Submission from the School Council for Sydney Boys High School, Moore Park, Surry Hills NSW 2010.

Subject of submission: Application No SSI 6042 MOD 1 - CSELR Modifications Assessment Report 3rd Dec 2014

i. Modification of concern to the SBHS School Council: Amended Design of the Moore Park Stop

Figure 4: Proposed modification to Moore Park stop

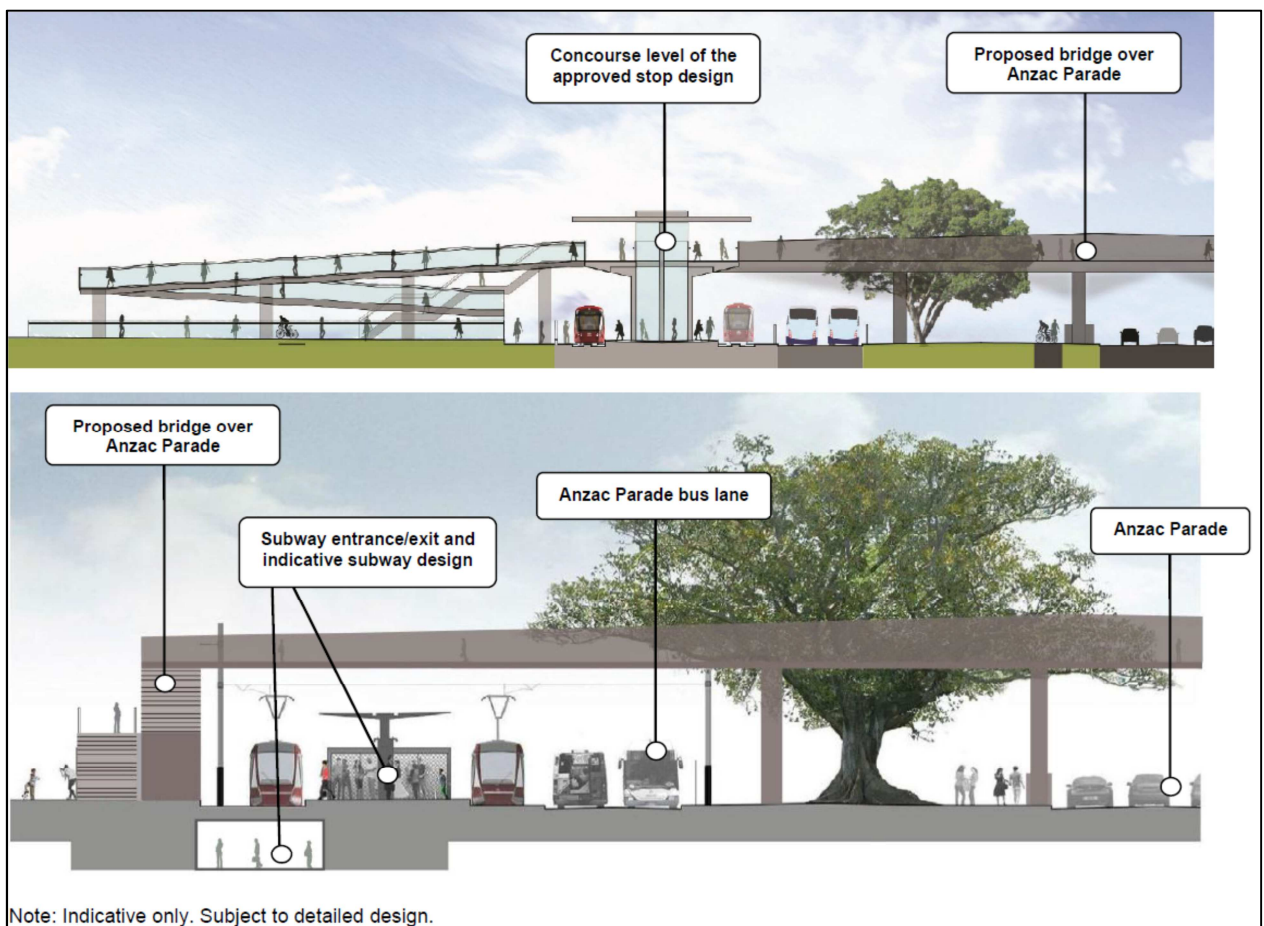
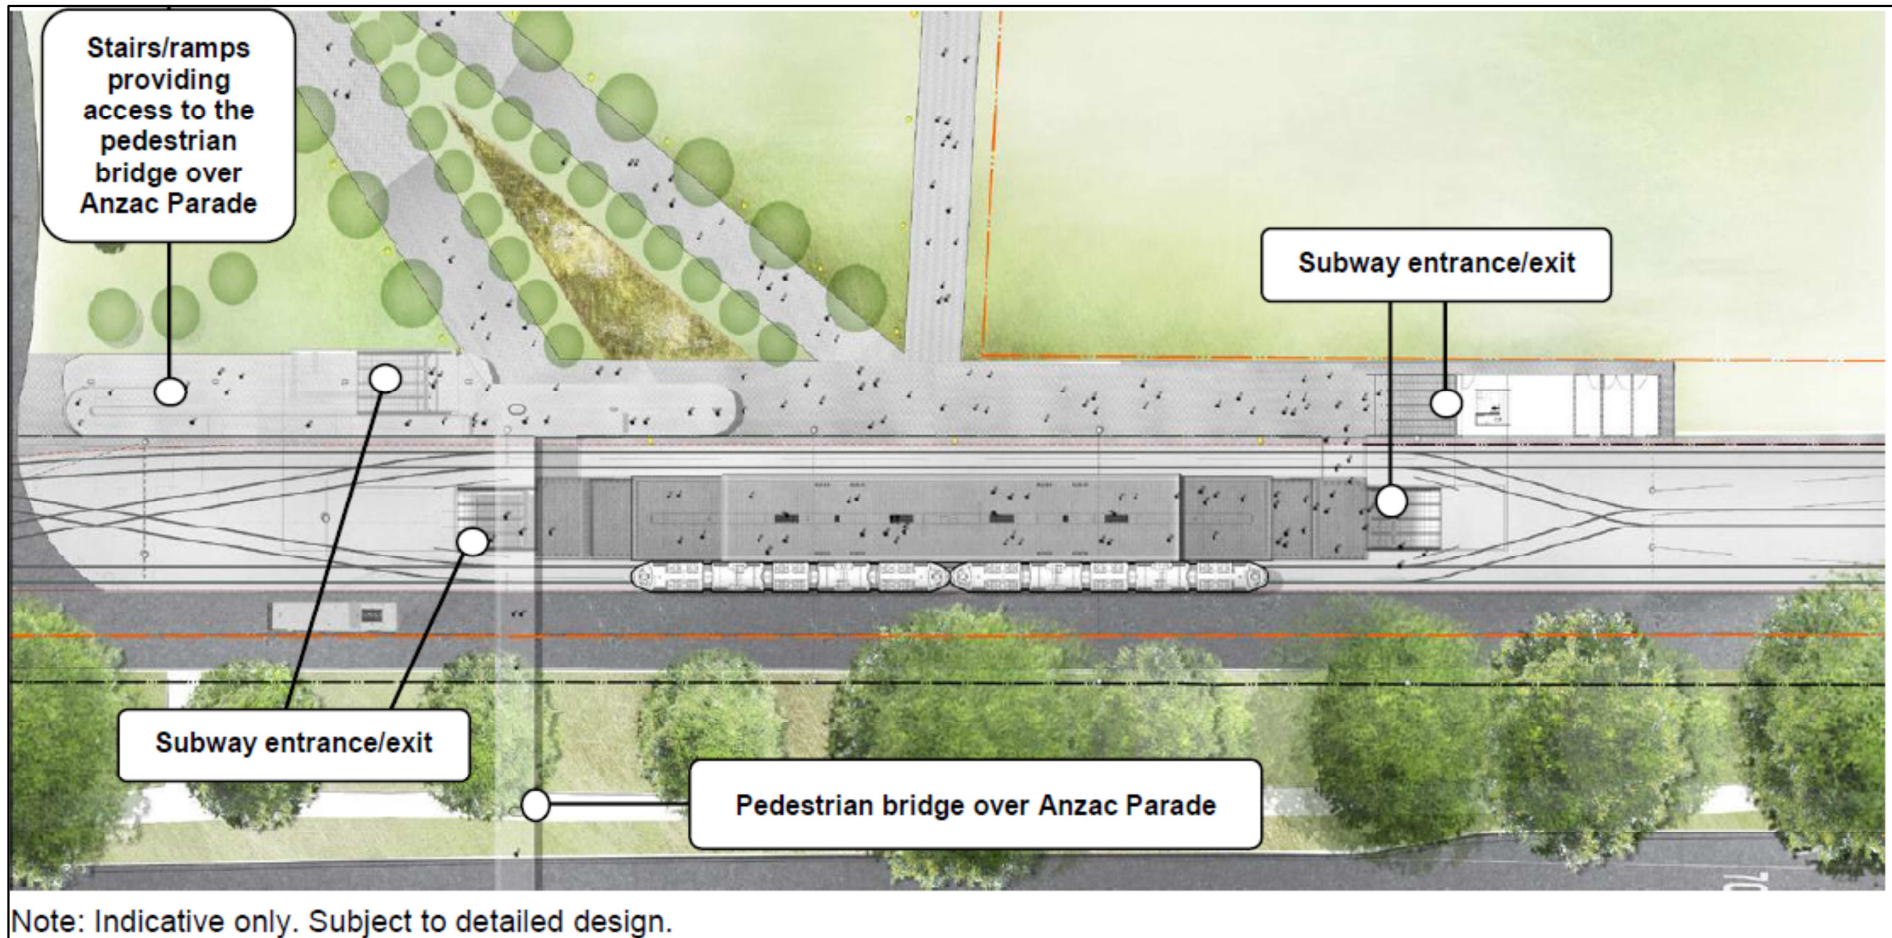
With the change in the Moore Park (MP) LR station from double storey to single storey, there will be no direct connection with the overhead bridge crossing Anzac Pde and joining the MP LR station to Sydney Boys High School (SBHS) and the adjacent Sydney Girls High School (SGHS).

This will mean school children in the afternoon peak period at around 3.15 PM will cross Anzac Pde on the overhead bridge and will then leave the bridge to reach the MP tram stop but in doing so will need to cross by foot one set of tram tracks. At this time (and it will be repeated in the morning rush hour at around 8.45 AM), up to approximately 1,500 children from SBHS and SGHS who take the LR from the MP station to Central railway station will be crossing tracks while trams will be leaving the MP station (see 4. Under Suggested changes below). This surge of school children cannot be compared to what will happen at other LR stops as suggested in the modification justification p18 3.5.2 para 3 *“Under normal operation, the MP stop would be accessed via pedestrian crossings over the LR tracks, and access ramps similar to all other stops”*. It is inconceivable that at “all other stops” there will be at least two occasions per school day when this large number of children will need to cross tram tracks unsupervised.

As far as can be ascertained from the modifications document there will be no additional safeguards in place for school children to cross tram tracks compared to the additional safeguards to deal with crowds emerging from sporting events i.e. for these special events there will be: (1) Underground subways opened to the public to avoid the crossing of tram tracks and, (2) Additional LR staff will supervise the public’s access to the MP station.

The justification for changing the MP LR station to single storey is to allow it to blend in with the environment, yet this comes at a cost to the safety of school children particularly at those two peak rush times when a large number will want to utilise the LR. The SBHS School Council does not accept that the proposed benefit outweighs the increased risk.

1. Stairs should be built from the overpass to allow the students to access directly the MP LR stop rather than requiring the students to walk the length of the overpass and then walk back to the MP LR stop by crossing tram tracks.

2. Provision is made to open the subway crossings to allow students to use these at peak school times (in the AM and PM). At non-peak school times, the risk for much smaller numbers of students crossing via the tram lines will be significantly reduced although not excluded.

3. Additional LR staff are provided to supervise students in the AM and PM peak times. Many of these school children live in distant parts of Sydney so failing to connect with their trains at Central station will encourage them to take risks to catch the LR tram.

4. Clarification is needed on the logistics for student transfer e.g. whether the same effort made at sporting events to move large numbers by starting with empty trams at the MP station will be made to ensure an effective and rapid transfer of students during the morning and afternoon peak times. For the former, the additional trams will need to start from Central railway station.
